HINCKLEY NATIONAL RAIL FREIGHT INTERCHANGE

Interim Stage 1 Road Safety Audit Response Report

Document reference: 21.1

Report Title:	Hinckley National Rail Freight Interchange – Interim Stage 1 RSA Response Report
Document Number:	HRF-BWB-HGN-RSA-RP-CH-0001
Prepared By:	BWB Consulting Ltd
Overseeing Organisation:	Leicestershire County Council
BWB Reference:	NTT2814

Appendix A Part 1 - General Arrangement Plan

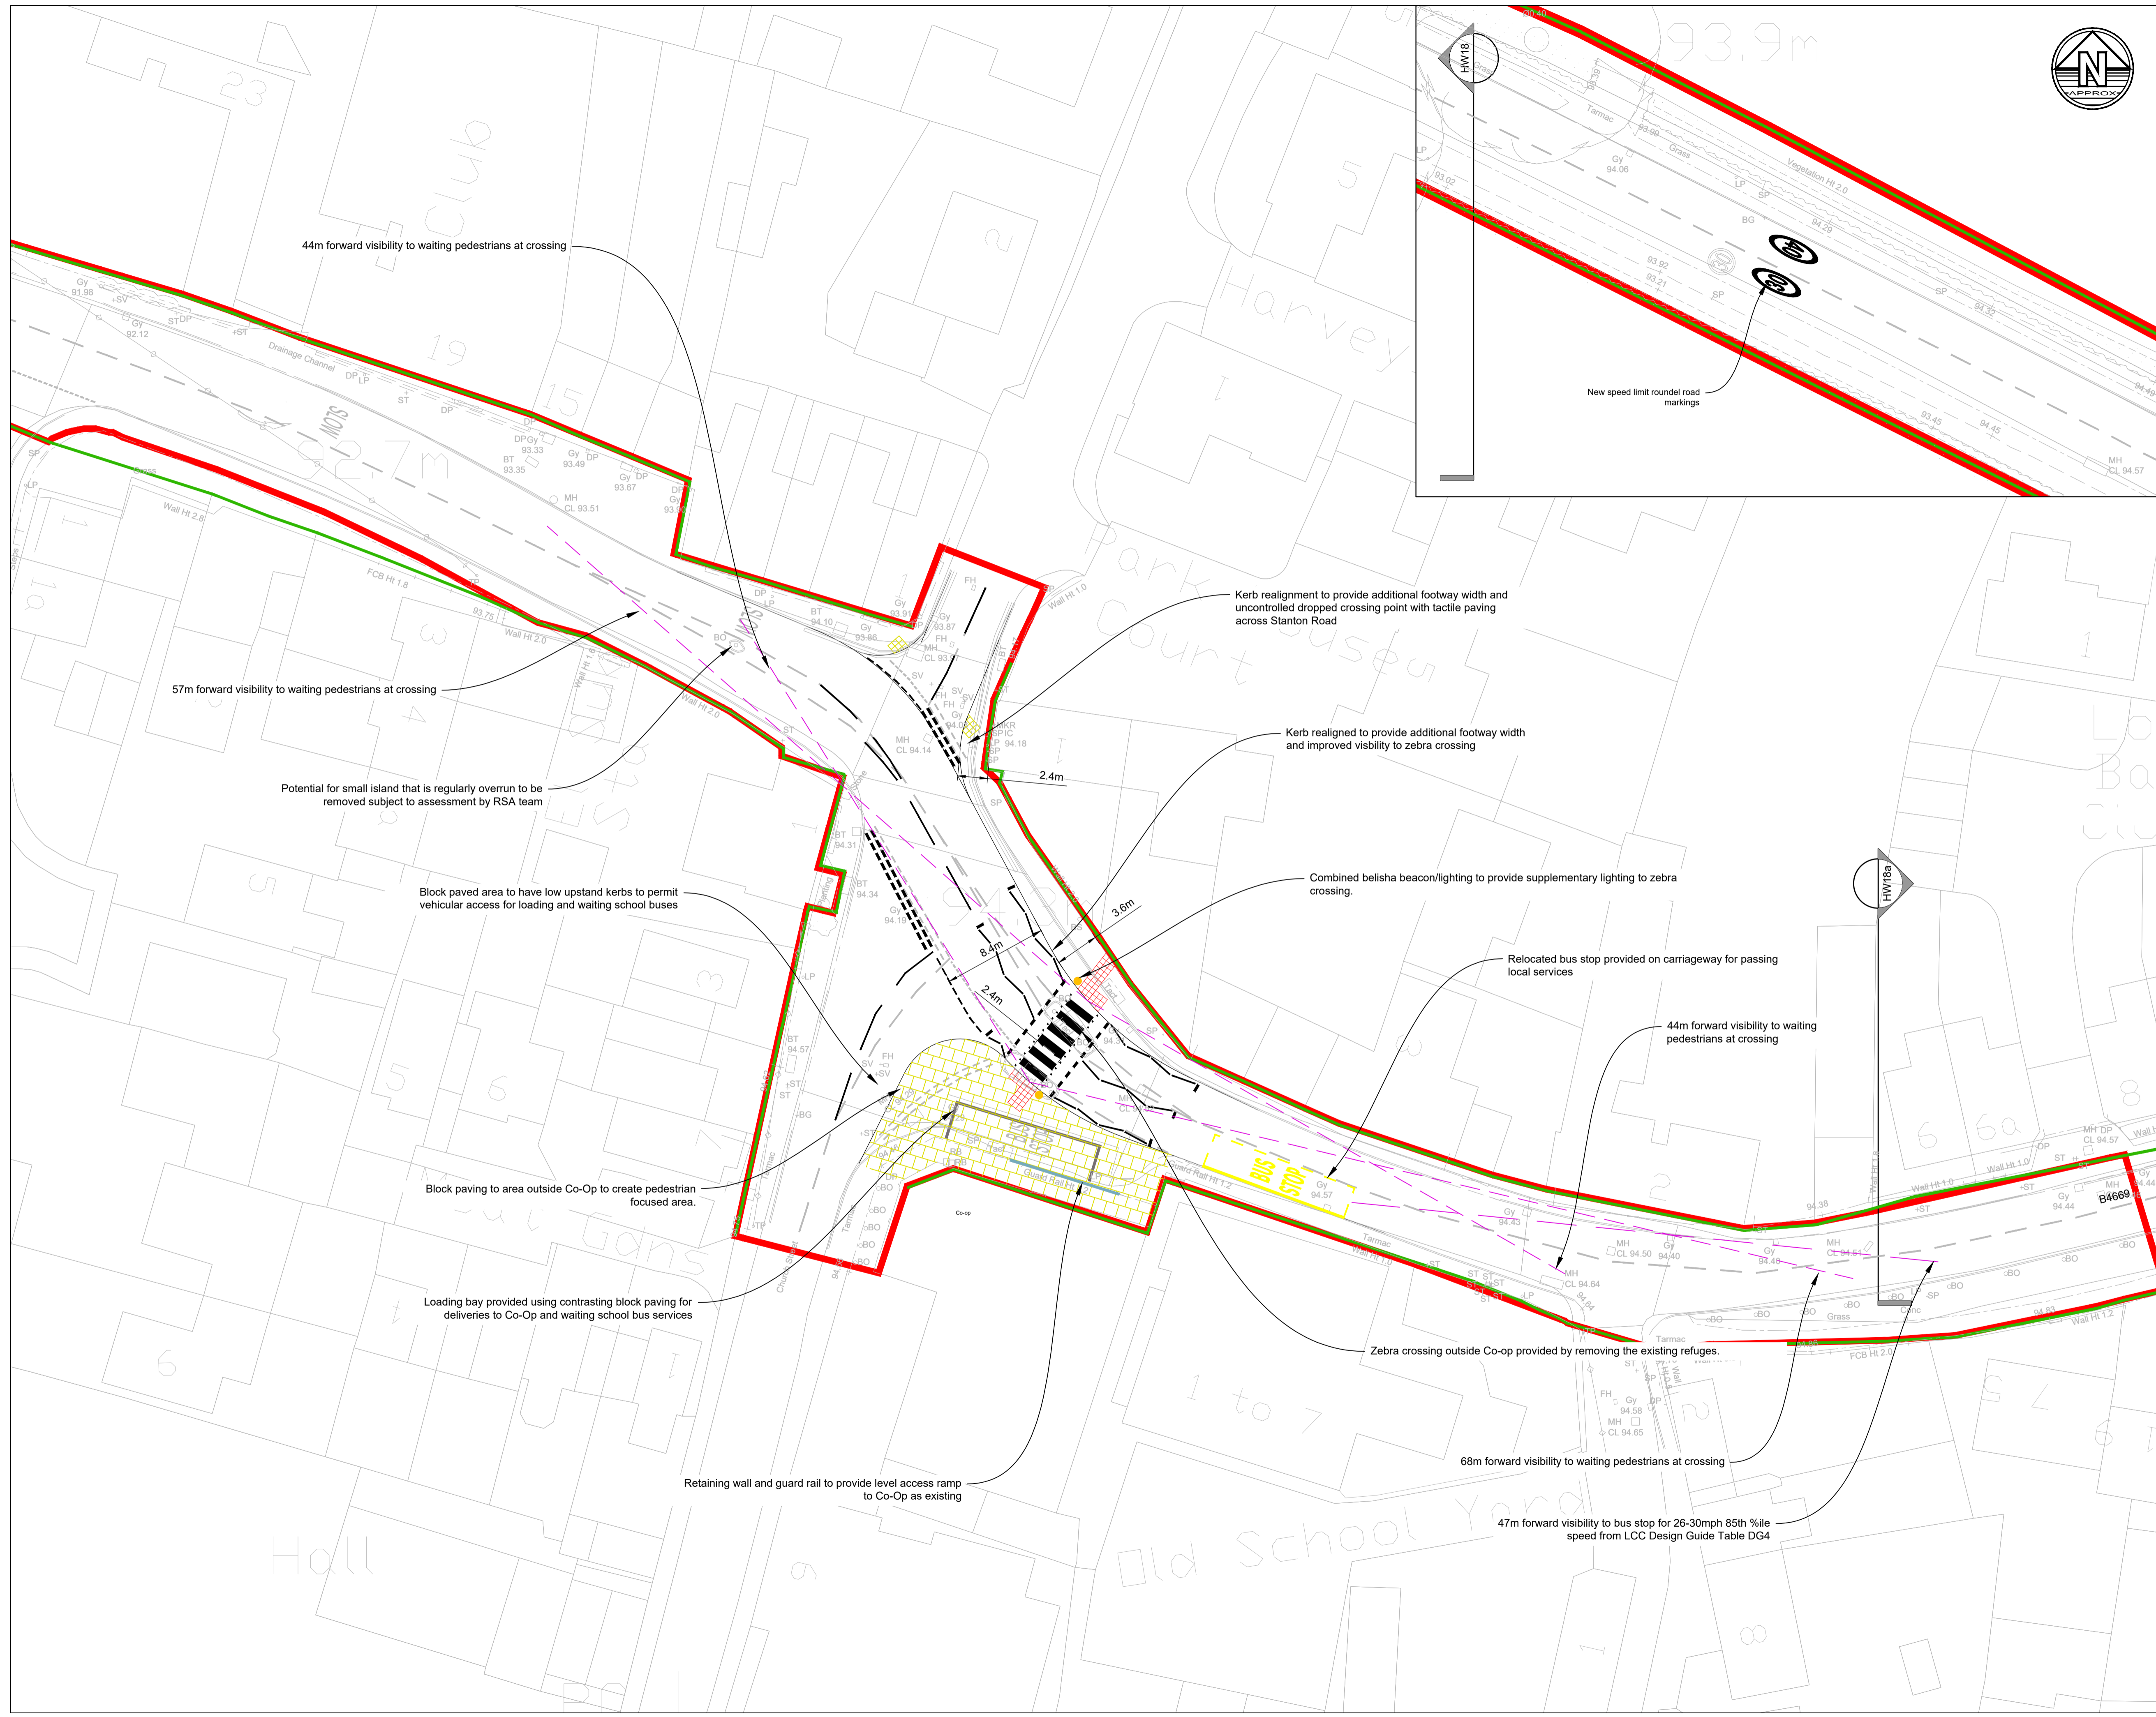
RSA Ref.	RSA Problem and Recommendation	Design organisation response	Overseeing organisation response	Agreed RSA action
	<p>Location: Proposed bus stop – adjacent to the Sapcote Church School.</p> <p>Summary: Lack of forward visibility risks head on collisions involving overtaking vehicles. The bus stop is to be relocated from a lay-by arrangement outside of the Co-Op to an on-carriageway location adjacent to the Sapcote Church School. This is close to a right-hand bend in Leicester Road where the building line obstructs forward visibility of eastbound vehicles. Should a driver or rider decide to overtake a stationary bus here there is a risk that they will not see or be seen by an eastbound vehicle, risking a head-on/side swipe type collision.</p> <p>Recommendation: It is recommended that the bus stop is relocated such that a westbound overtaking vehicle will be able to complete their manoeuvre safely and with adequate forward visibility based on the speed of approaching, eastbound vehicles.</p>	<p>Agree with RSA recommendation: Yes</p> <p>The on carriageway bus stop adds to the general traffic calming features that are proposed through Sapcote in order to make this route less desirable for re-routeing traffic and therefore vehicles should be discouraged from overtaking stopped buses. The location of the bus stop has been considered to ensure that suitable visibility is available to parked buses. In addition, 47m of forward visibility (in line with LCC Table DG4) is available from behind a parked bus to oncoming vehicles so that should vehicles decide to overtake a parked bus, they are able to see oncoming vehicles. The designer has realigned the northern kerbline of the B4669 to improve forward visibility for eastbound vehicles.</p>

RSA Ref.	RSA Problem and Recommendation	Design organisation response	Overseeing organisation response	Agreed RSA action
3.3	<p>Location: Leicester Road - proposed Zebra crossing</p> <p>Summary: Restricted visibility risks vehicle to pedestrian collisions.</p> <p>When crossing north to south, visibility for and of pedestrians crossing or waiting to cross is restricted to the east by the building line and boundary wall of the adjacent properties. This would be especially the case for wheelchair and pushchair users. Should they enter the carriageway when unsafe to do so there is a risk of vehicle to pedestrian collisions.</p> <p>Recommendation:</p> <p>It is recommended that unobstructed pedestrian visibility commensurate with measured vehicle speeds is provided at the crossing point.</p>	<p>Agree with RSA recommendation: Yes</p> <p>While the zebra crossing replaces an existing uncontrolled crossing and is seen as an improvement in pedestrian safety, the designer has reviewed the location and the northern B4669 kerb line has been amended to provide more footway width and to ensure suitable forward visibility to users waiting to use the crossing. This is illustrated on the revised drawings.</p>

RSA Ref.	RSA Problem and Recommendation	Design organisation response	Overseeing organisation response	Agreed RSA action
3.4	<p>Location: Leicester Road – footway to the east of the proposed Zebra crossing.</p> <p>Summary: Narrow footway risks vehicle to pedestrian collisions. The footway immediately to the east of the proposed Zebra crossing is very narrow (<1m), with insufficient width for two-way pedestrian movements meaning pedestrians have to enter the carriageway in order to pass one another at a point where visibility of eastbound traffic is obscured by the adjacent property (refer to Problem 2). The location of the crossing will encourage an increase pedestrian movements along this narrow footway, risking vehicle to pedestrian collisions Recommendation:</p> <p>Recommendation:</p> <p>It is recommended that the crossing is relocated to a location where sufficient footway widths on the approaches are available.</p>	<p>Agree with RSA recommendation: In Part</p> <p>The zebra crossing is a replacement for an existing uncontrolled crossing point and as a result additional pedestrians are unlikely to utilise the narrow section of footway. It is the opinion of the designer that a controlled crossing point makes it more likely that pedestrians will choose to cross the road to avoid using the narrow section of footway and as a result, the proposals reduce the safety risk posed by this existing section of footway. This said, the designer has revised the northern kerbline of the B4669 to provide a wider footway where possible and to enhance visibility to pedestrians crossing. Furthermore, the removal of the central islands on the B4669 means that large vehicles are less likely to mount the kerbs as they have the full width of the carriageway in which to manoeuvre rather than being restricted in width by refuge islands.</p>

RSA Ref.	RSA Problem and Recommendation	Design organisation response	Overseeing organisation response	Agreed RSA action
4.1	Whilst on site it was observed that several vehicles were parked along the western side of Church Street. With the proposed amendments to the kerbline here, vehicles parking here will potentially cause an obstruction to turning large vehicles and to visibility for and of emerging vehicles. It is therefore recommended that, as part of the detailed design, waiting restrictions are provided at the junction.	The designer has considered this point and revised the design to leave this section of Church Street unchanged, meaning that vehicles that currently park along this stretch of carriageway (noting the presence of several driveways) will continue to be able to do so.
